The North Wales Wind Farms Connection Project

SP Manweb's Response to Submissions from
Interested Parties submitted at Deadline 5

Application Reference: EN020014

Author	SP Manweb
Date	December 2015
Version	V1
Planning Inspectorate Reference No.	EN020014
Document reference	SPM NWWFC PHSIPD5

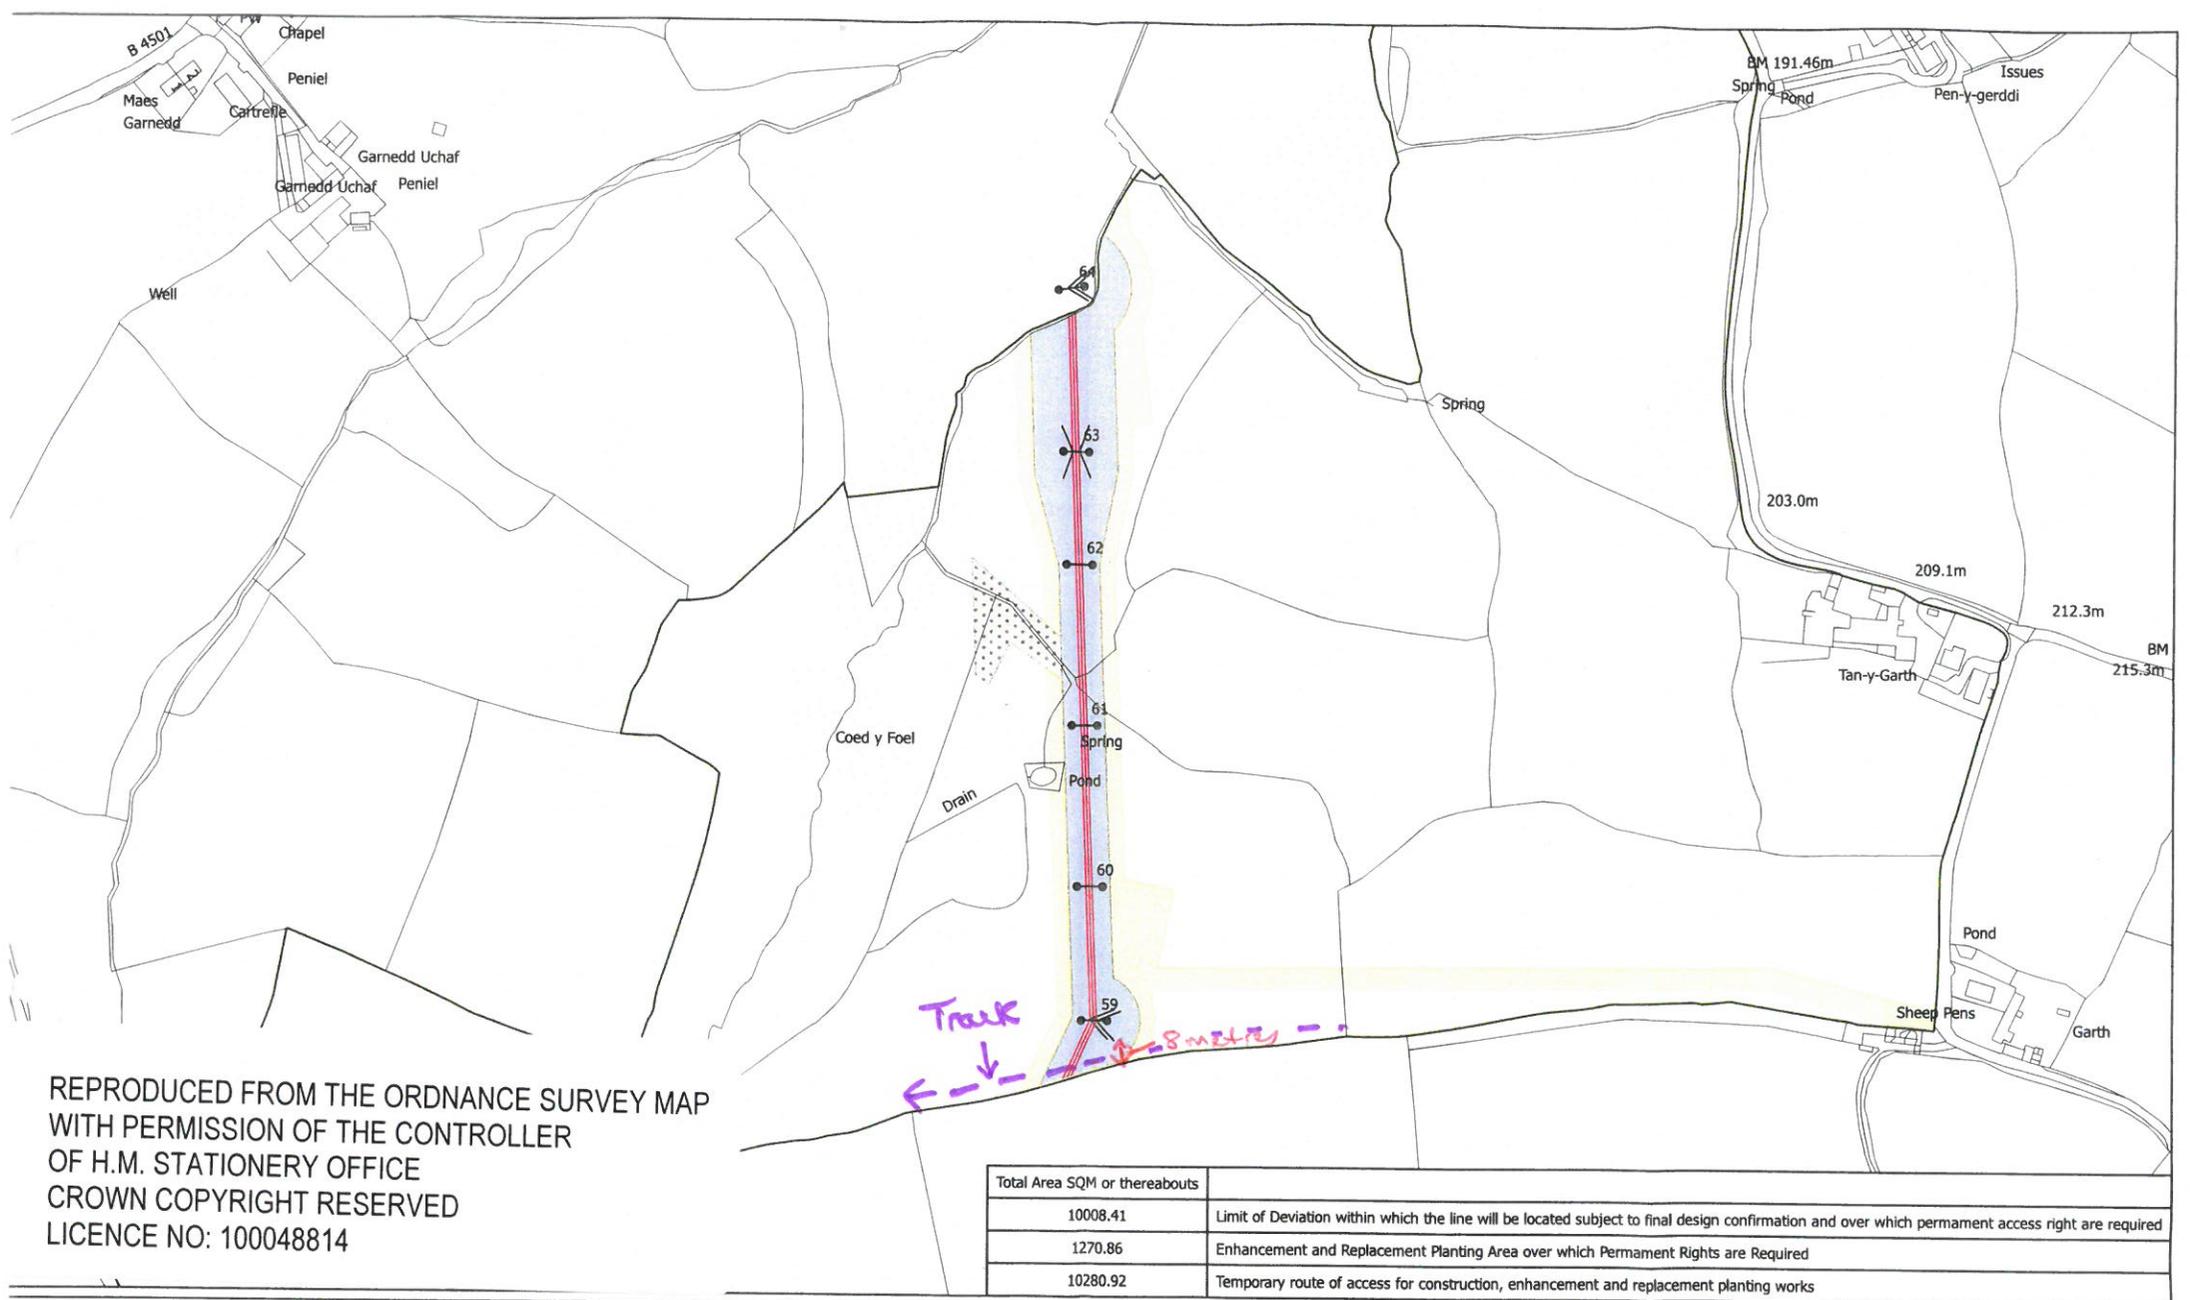
<p>Eifion Bibby on behalf of J E Davies (Plot 24)</p>	<p><u>Option B pole locations</u> Pole 59 and stays to be sited 8 metres away from the neighbouring field boundary to the south.</p>	<p>This suggestion has been accepted and is included in the Option B submission. Please see Comparison Plans Sheet 3 Document reference OPTIONB CP.3 ((Examination Library reference OpB-013).</p>
<p>Eifion Bibby on behalf of J E Davies (Plot 24)</p>	<p><u>Enhancement and replacement planting</u> Requests clarification on areas required permanently for proposed for enhancement and replacement planting. The recent plan forwarded from the applicant to the interested party is not sufficiently clear.</p>	<p>SP Manweb has clearly explained in its response to SWQ 8.1(a) (Examination Library reference REP6-035) when landowners can "veto" planting and when they will be consulted on planting. See also Appendix 10 to SP Manweb's Written Summary of its Oral Case put forward at the Issue Hearing Specific Hearing Day 2. The submitted Landscaping Plans illustrate hedgerows that are likely to contain trees, however, the plans were misinterpreted by some interested parties to read as a continuous line of trees. This has never been the intention, as explained at the Oral Hearings, the plans highlight the difference between a hedge with no hedgerow trees, and a hedge with some</p>
